ROLLING MEADOWS/BULL HILL

TRAFFIC IMPACT STUDY

El Paso County, CO

August 31, 2023

SHEET TITLE:
SKETCH PLAN
SKP02
 SHEET 02 OF 03

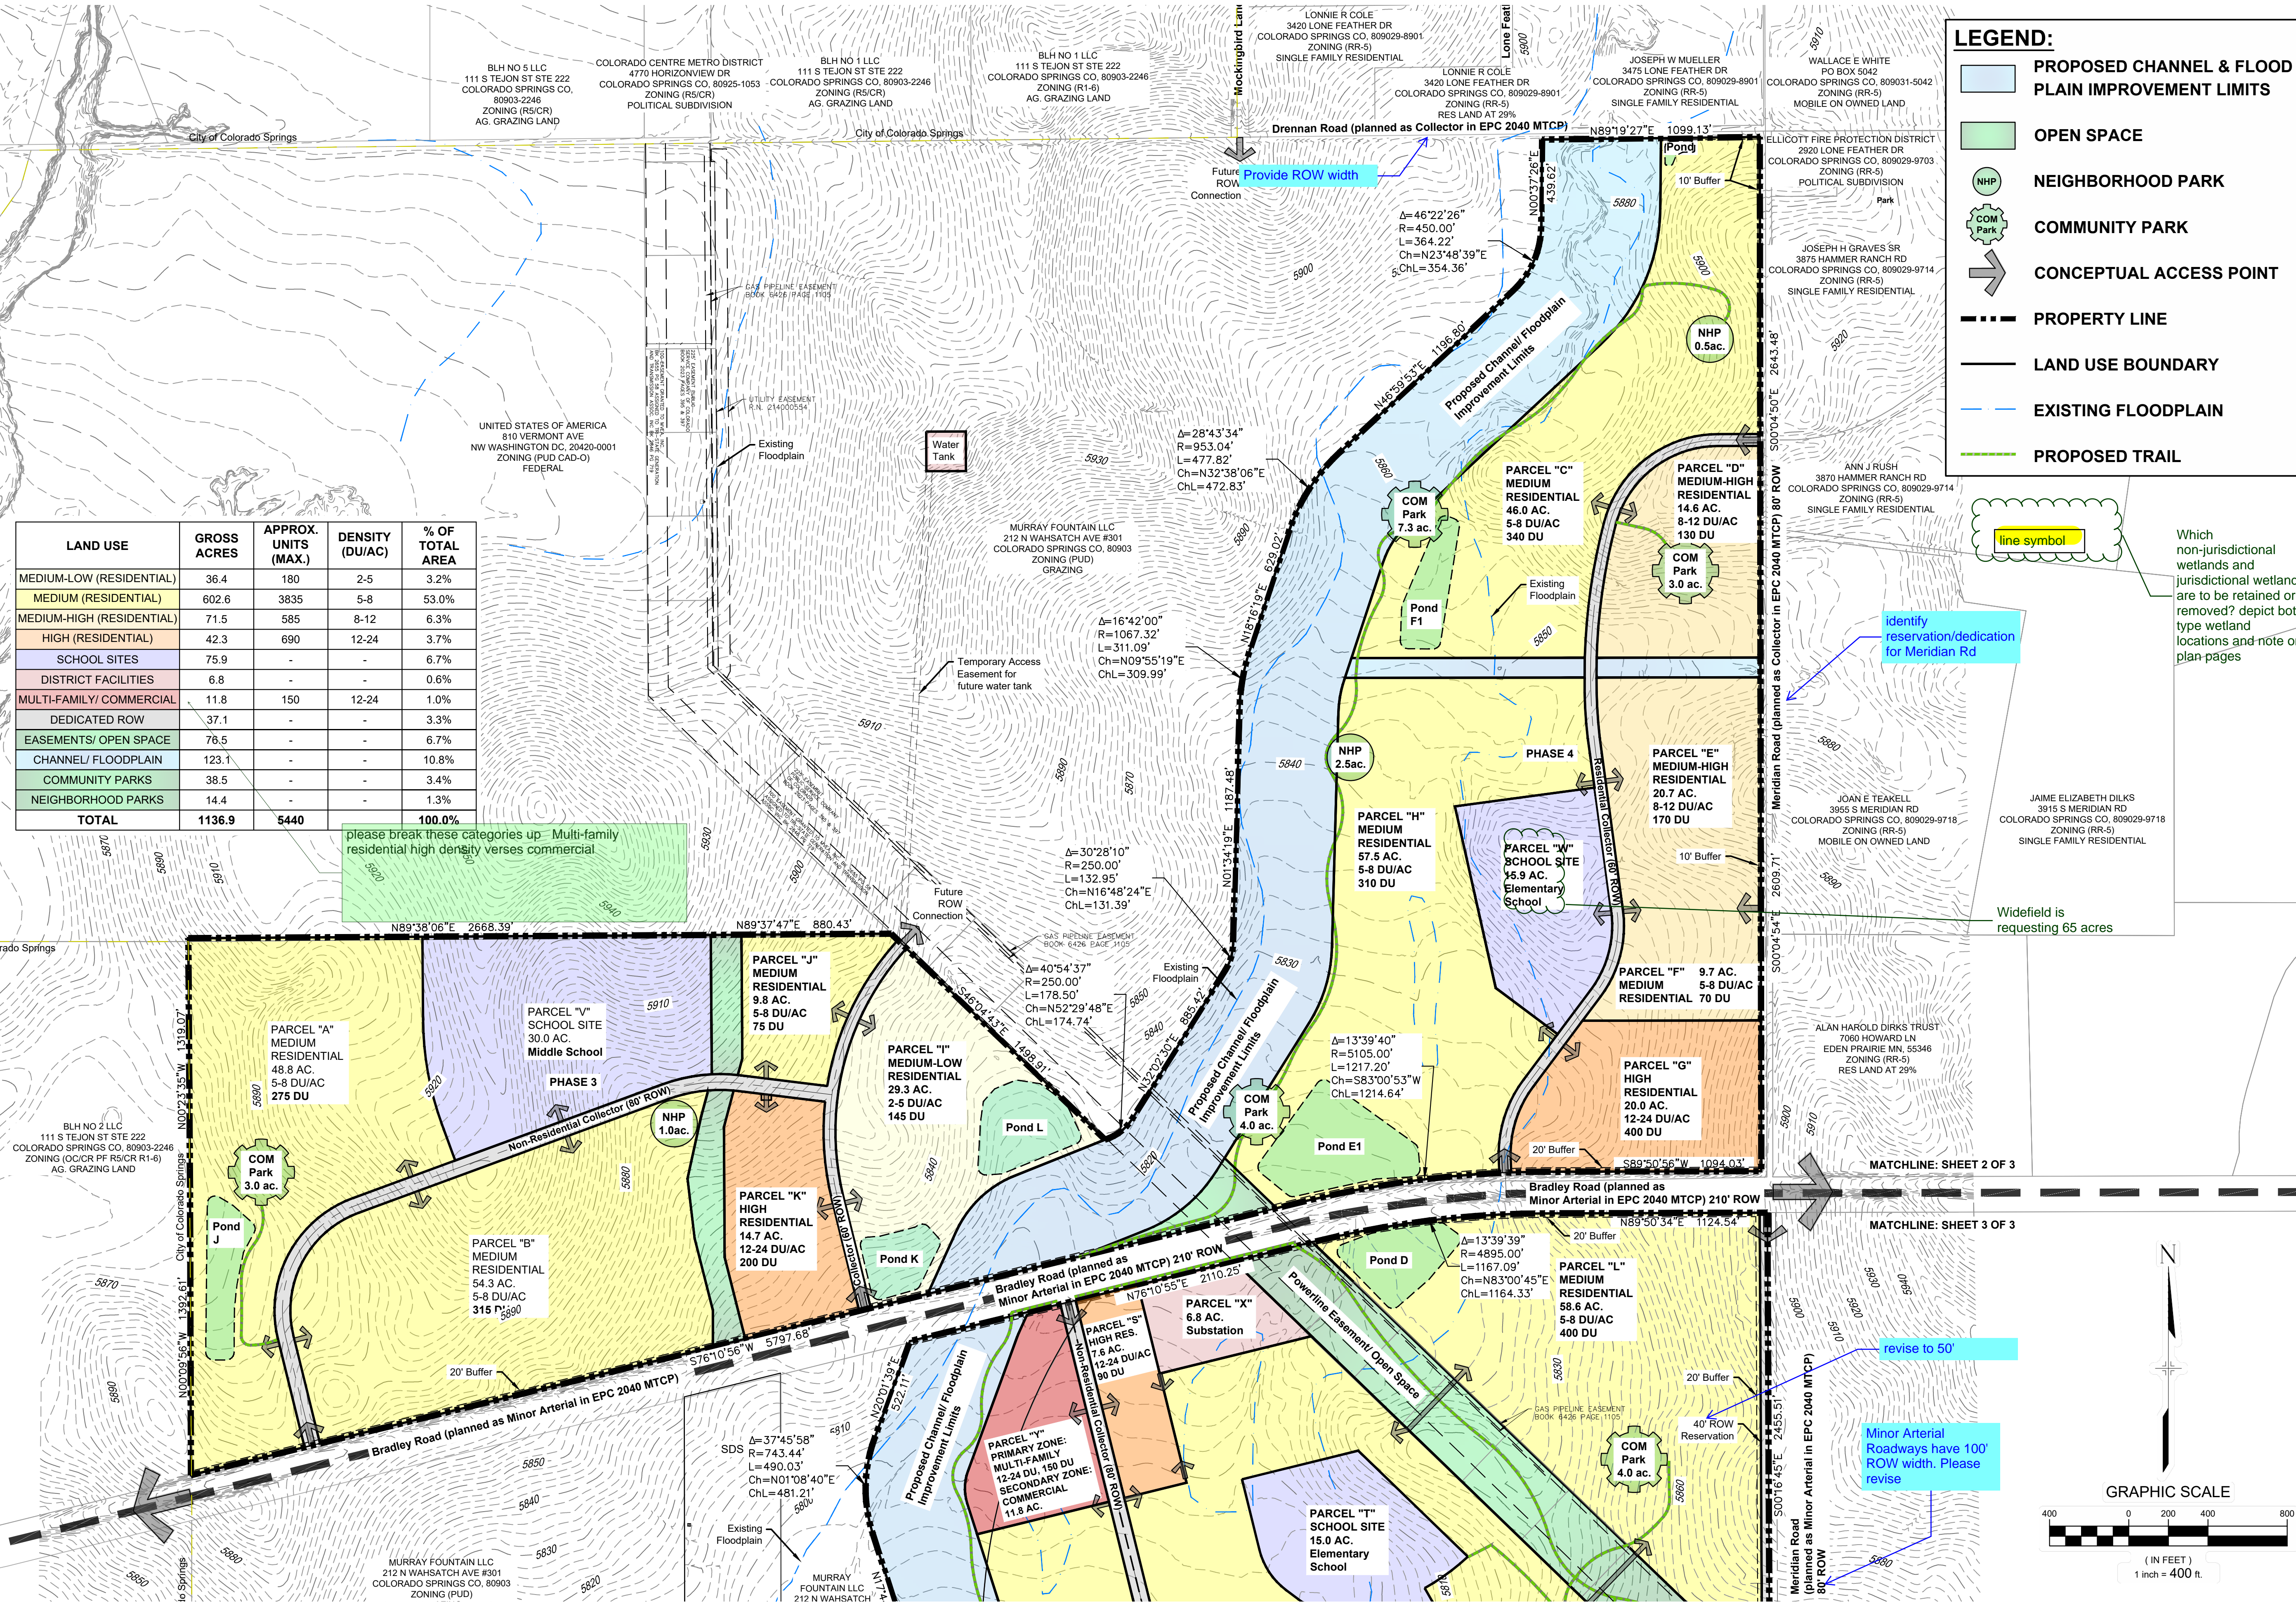
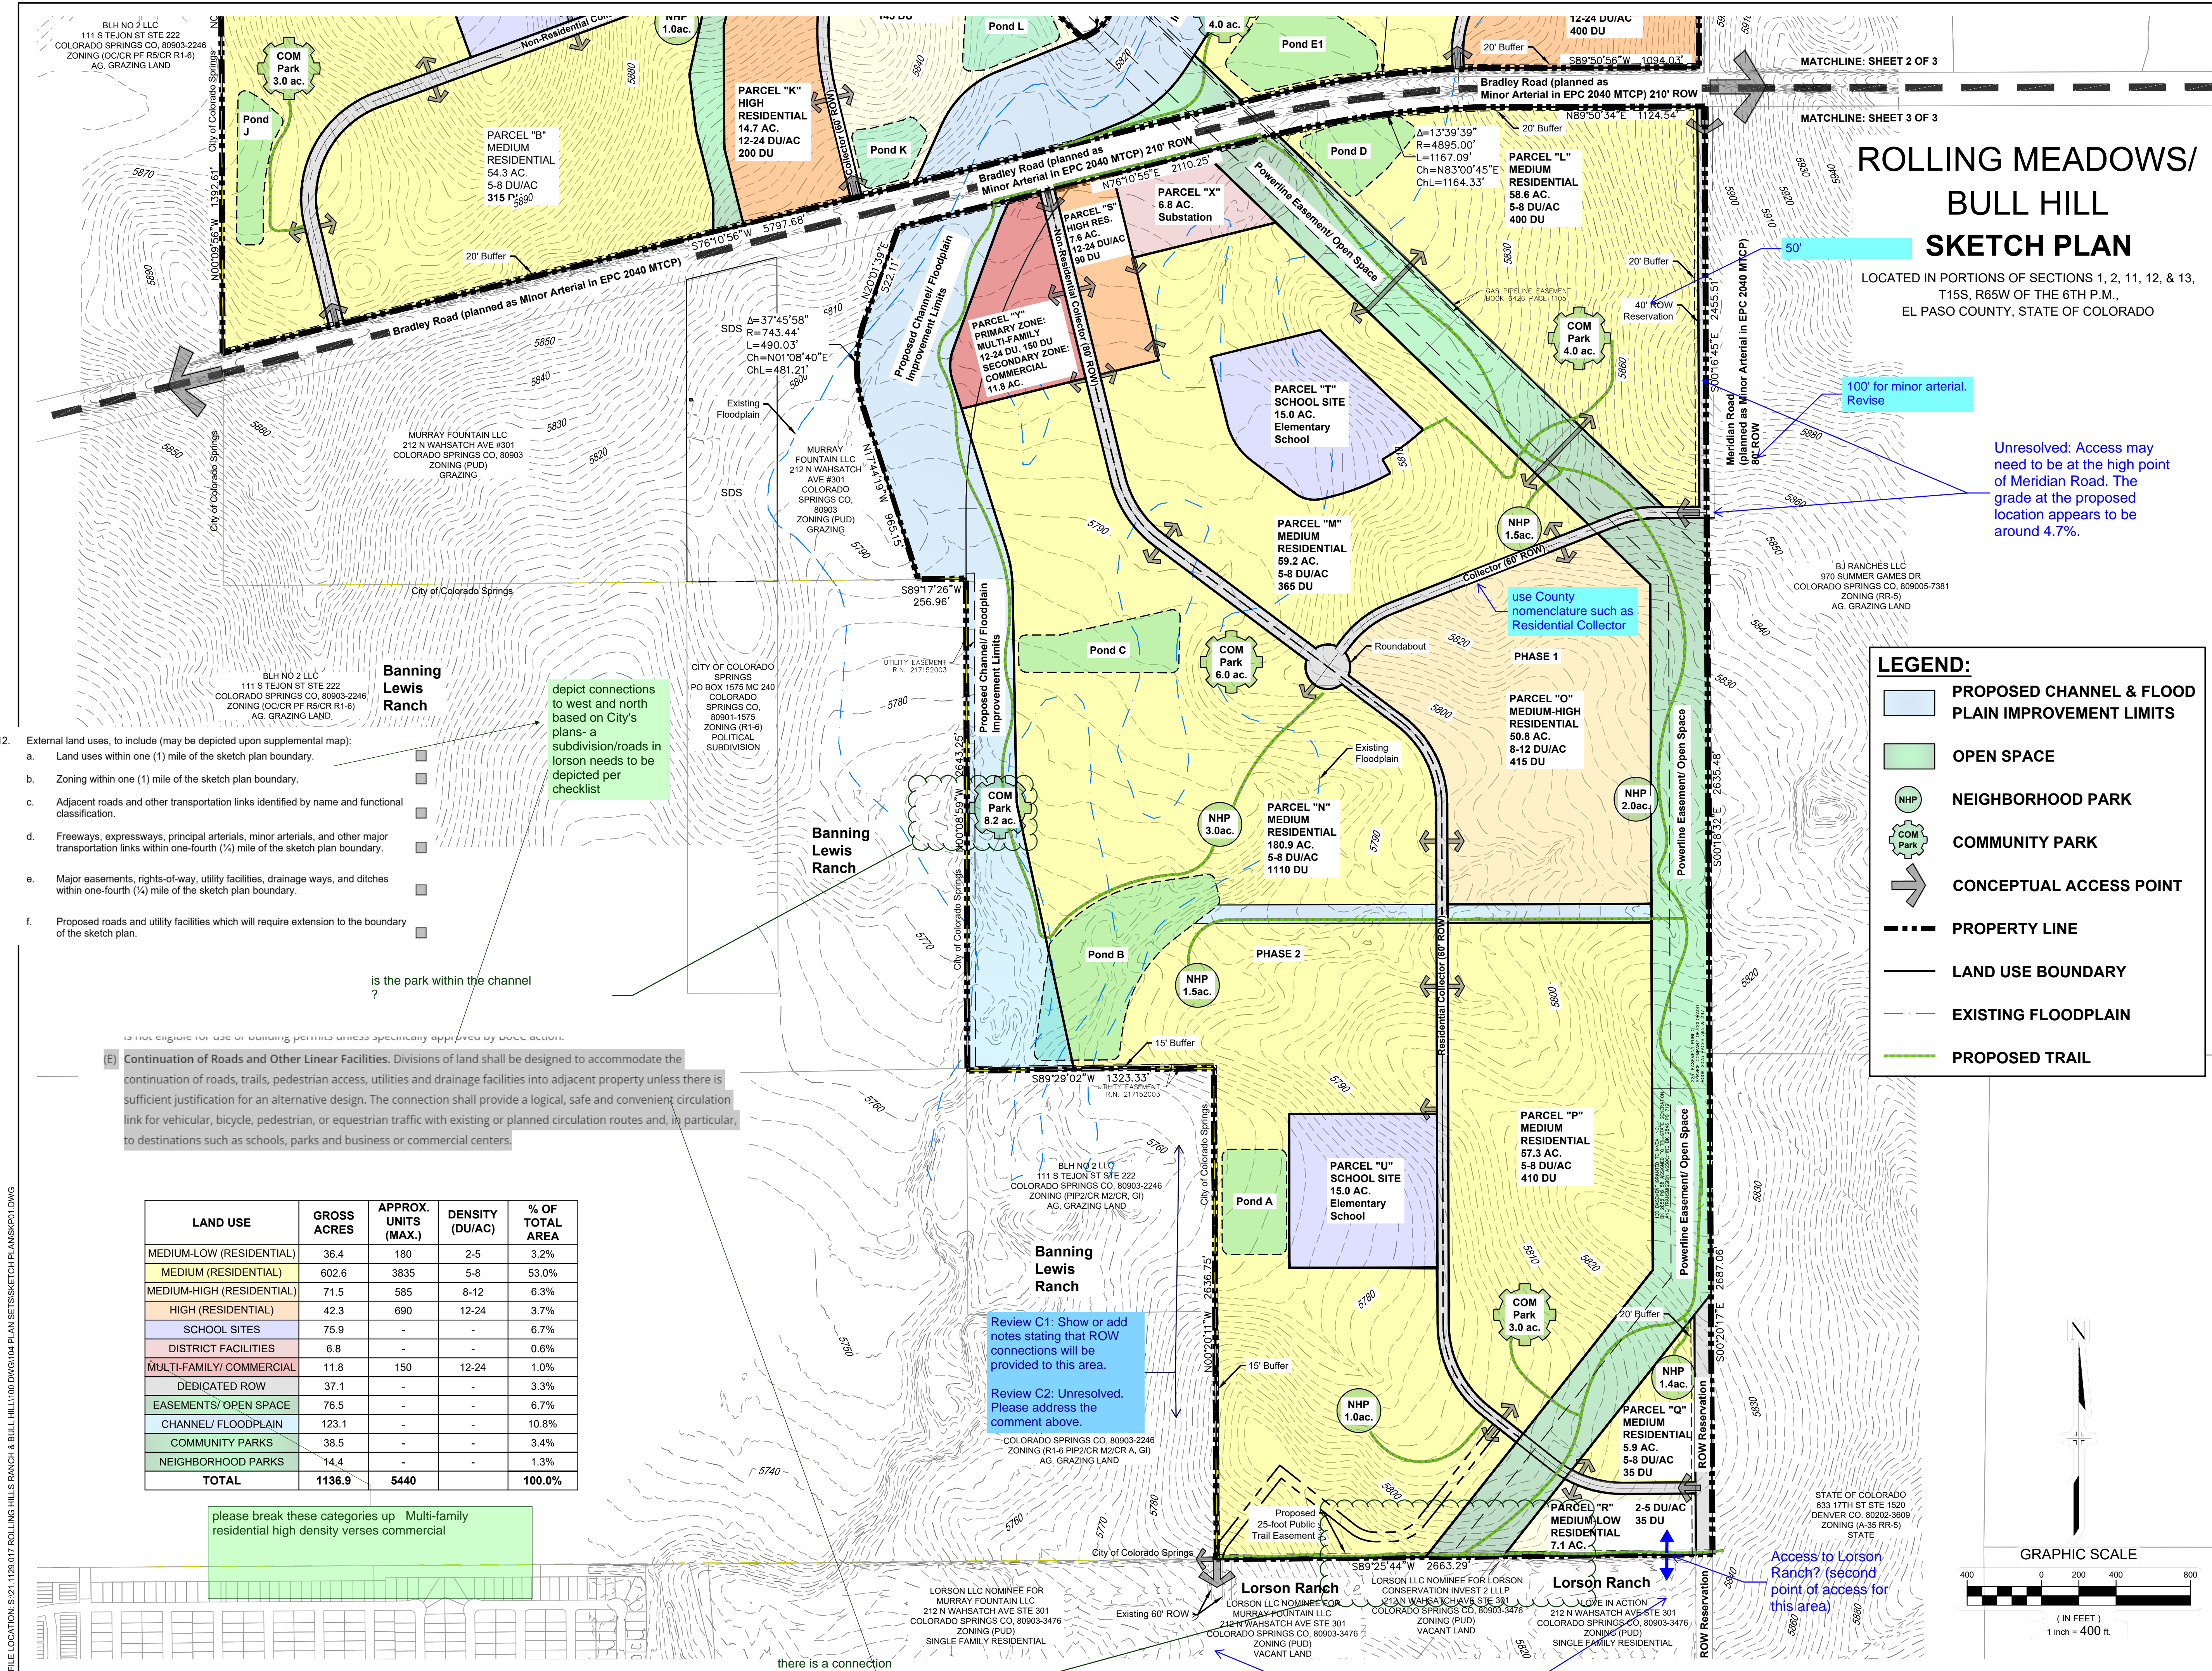
see comments on intersection locations on sketch plan
